Application for Planning Permission

Development: 1 No 4 bed chalet bungalow. This application is in CIL Zone 4 and is CIL Liable as a new dwelling.
Location: Dawn Cottage 44 Pagham Road Pagham PO21 4NP

Proposed North Elevation 44

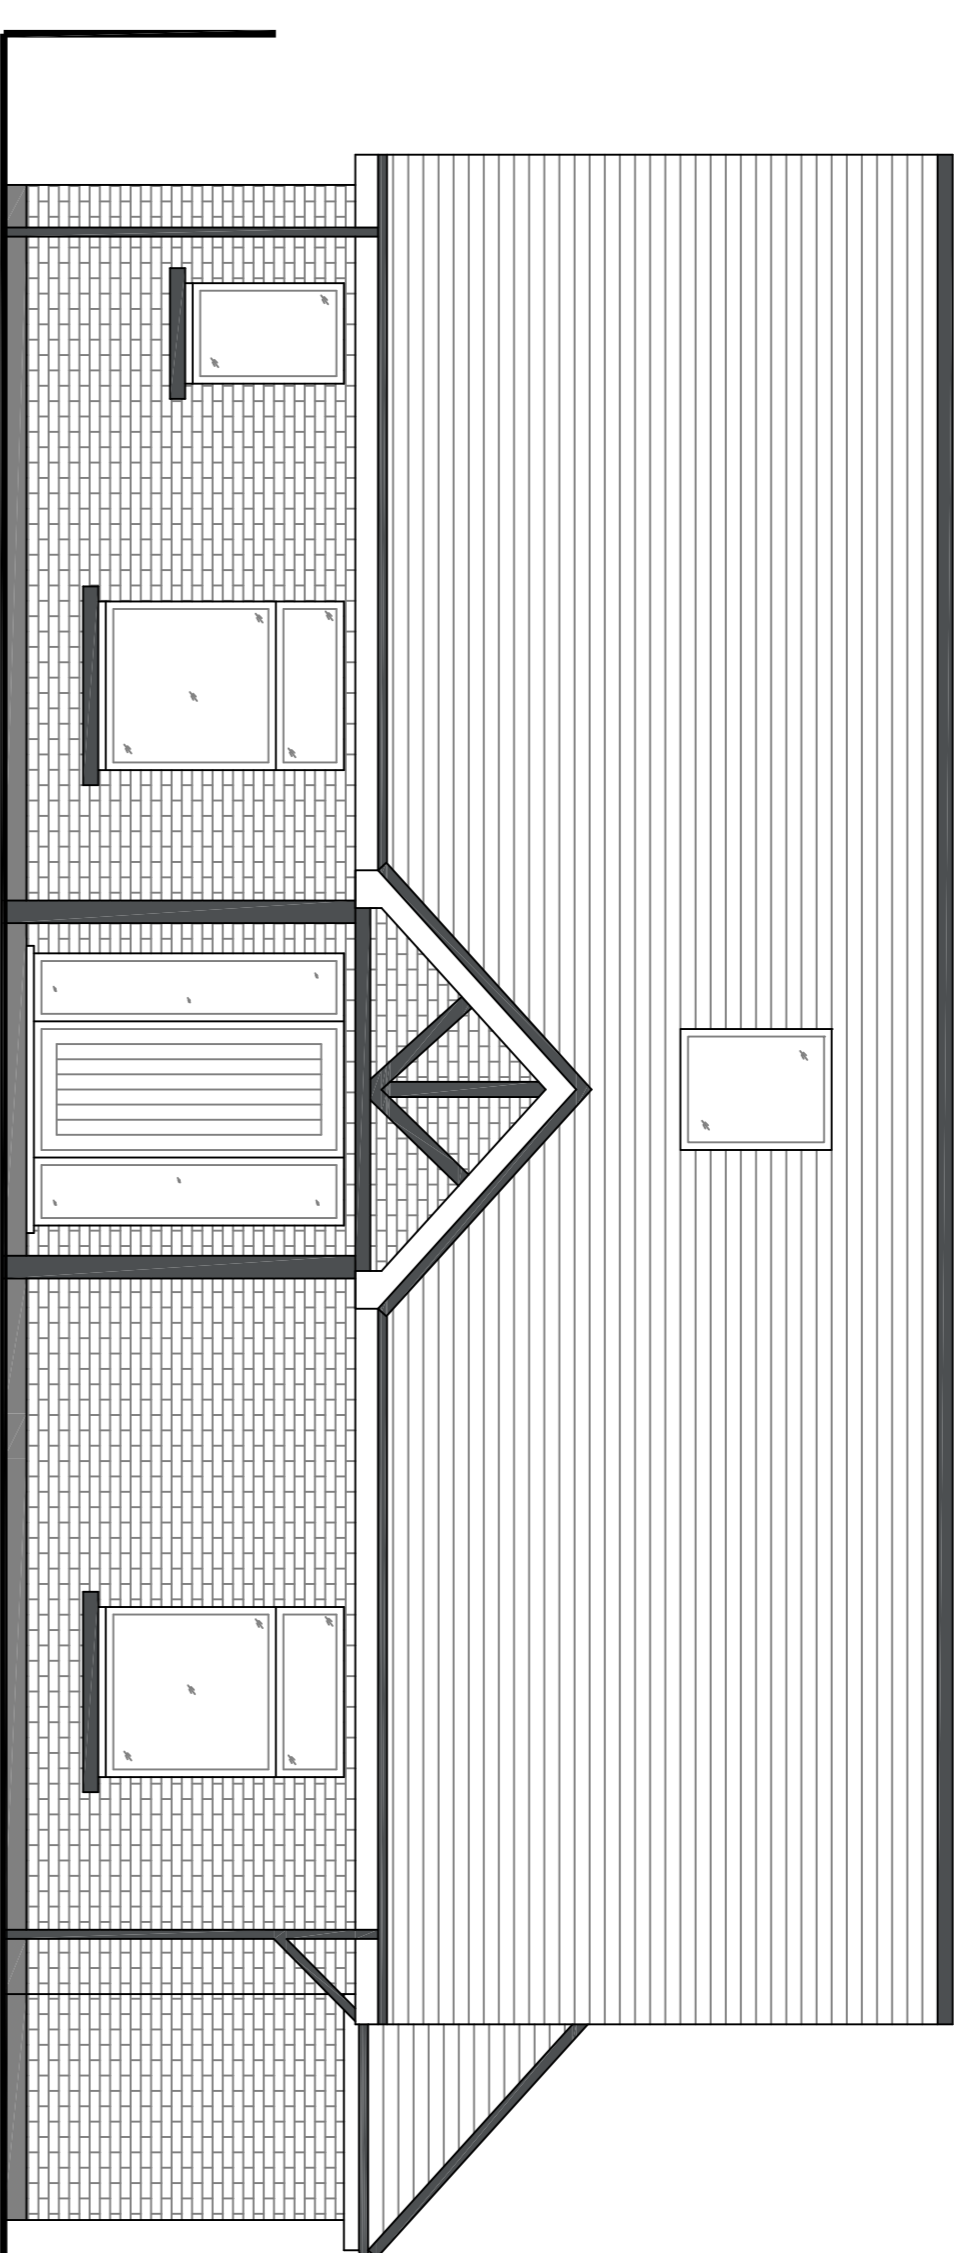
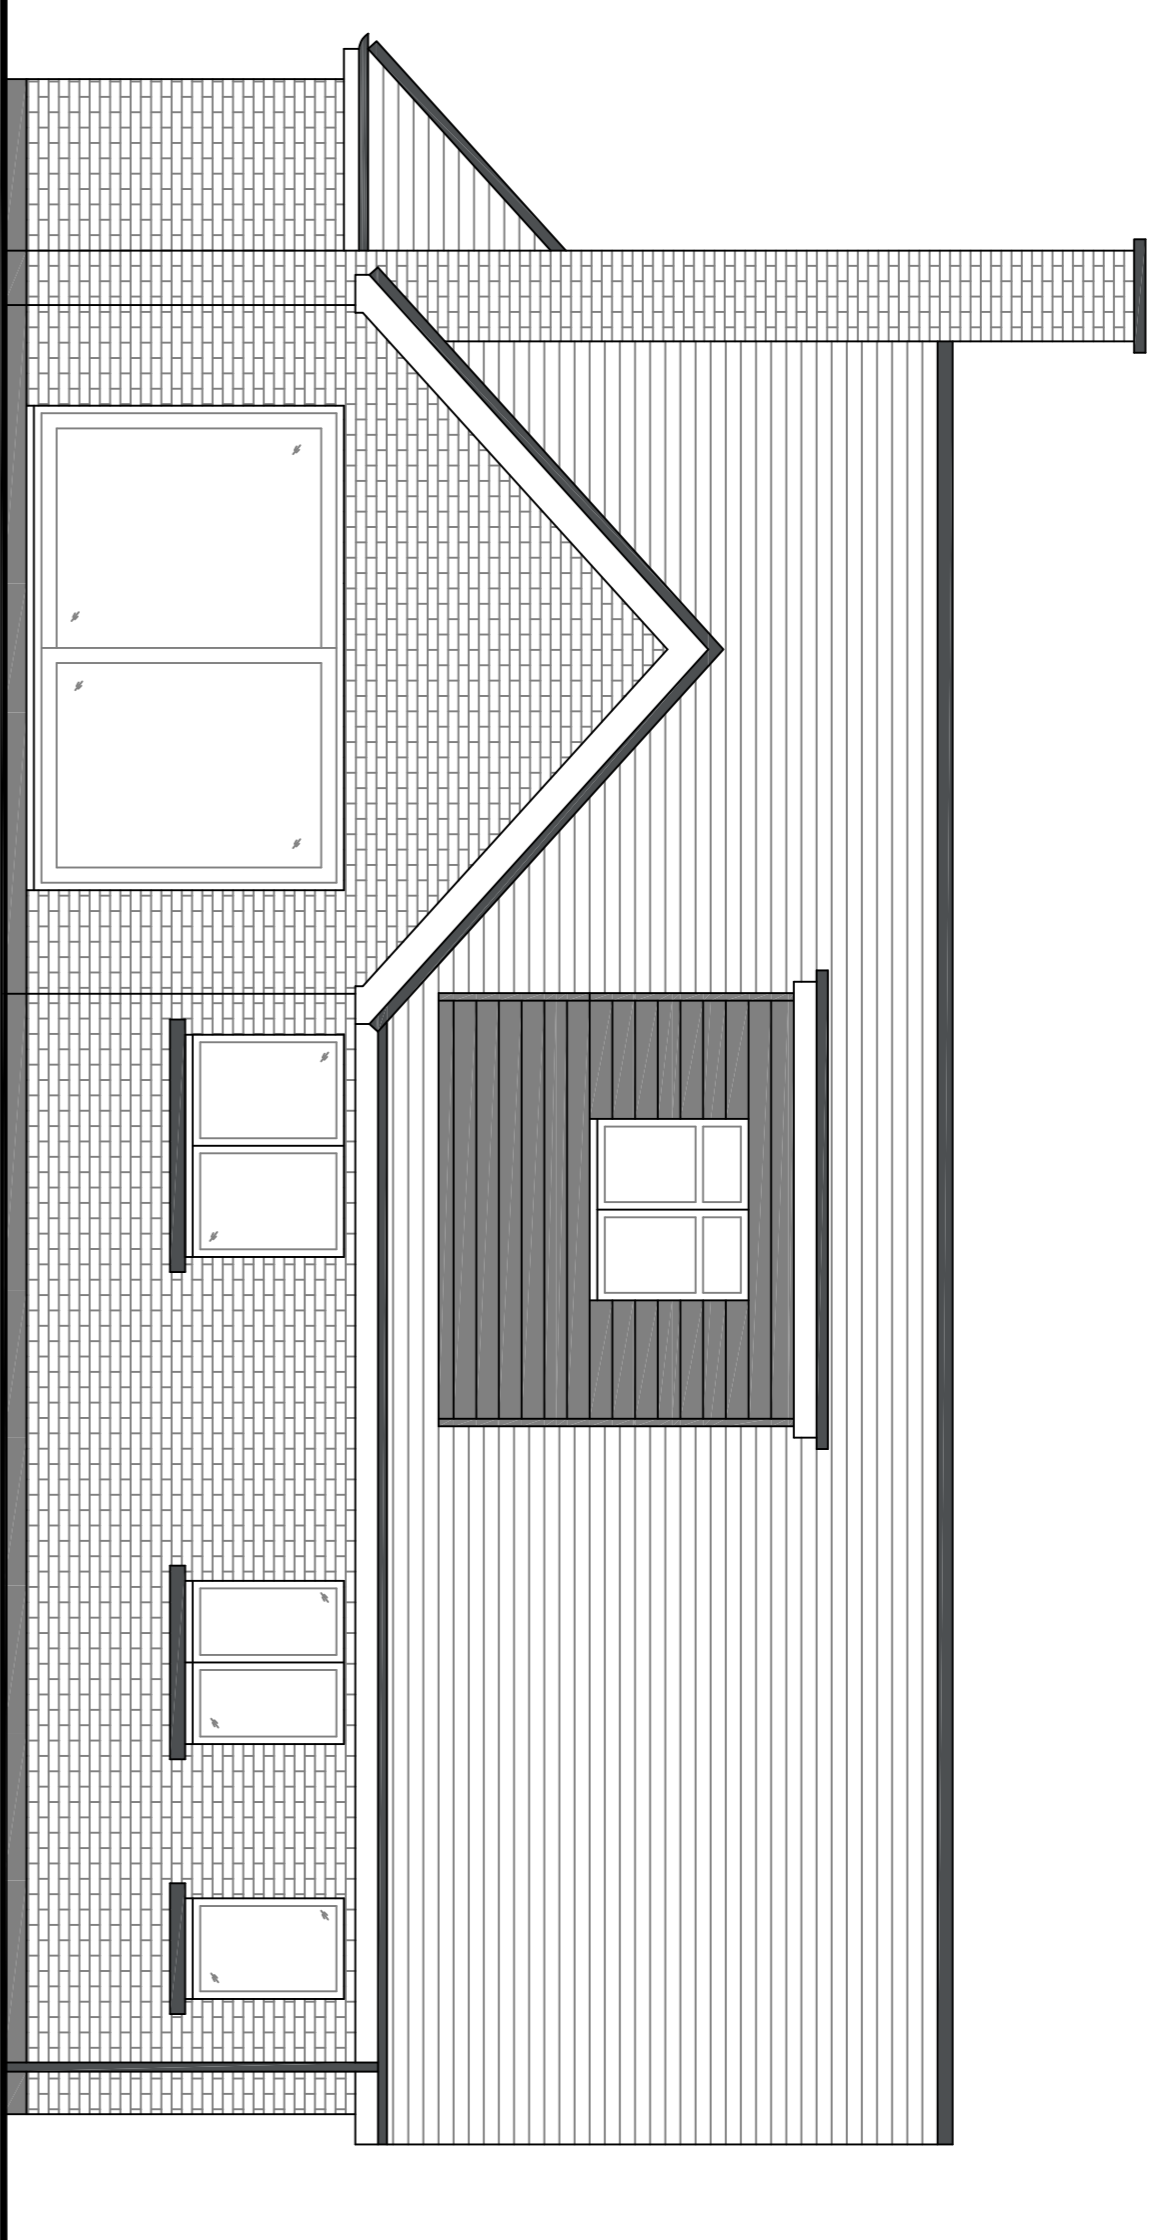
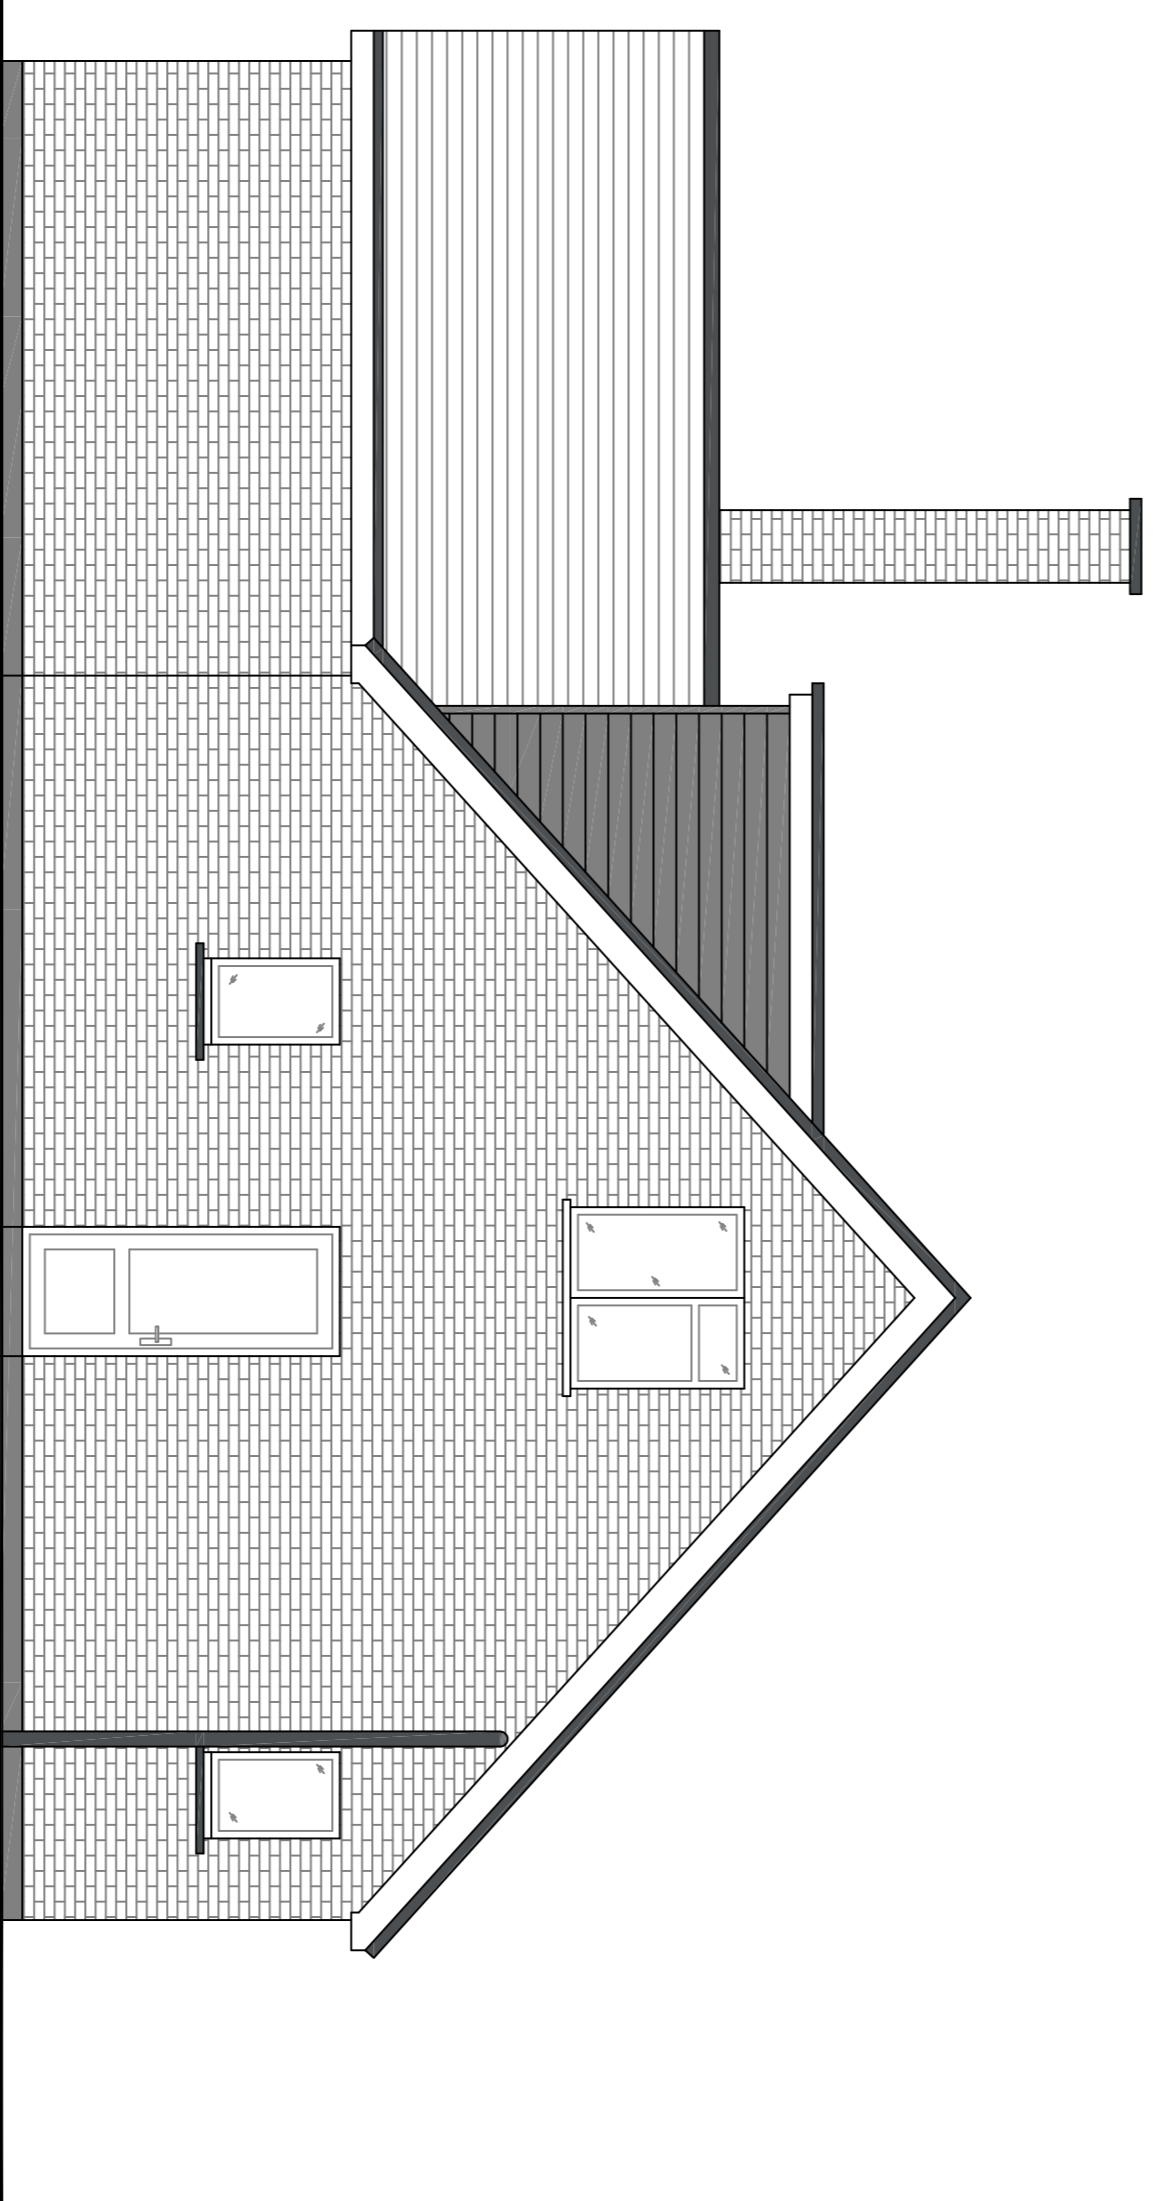
Please confirm why you have supplied two existing and proposed north and south elevations and east and west elevations as the elevations are the same.
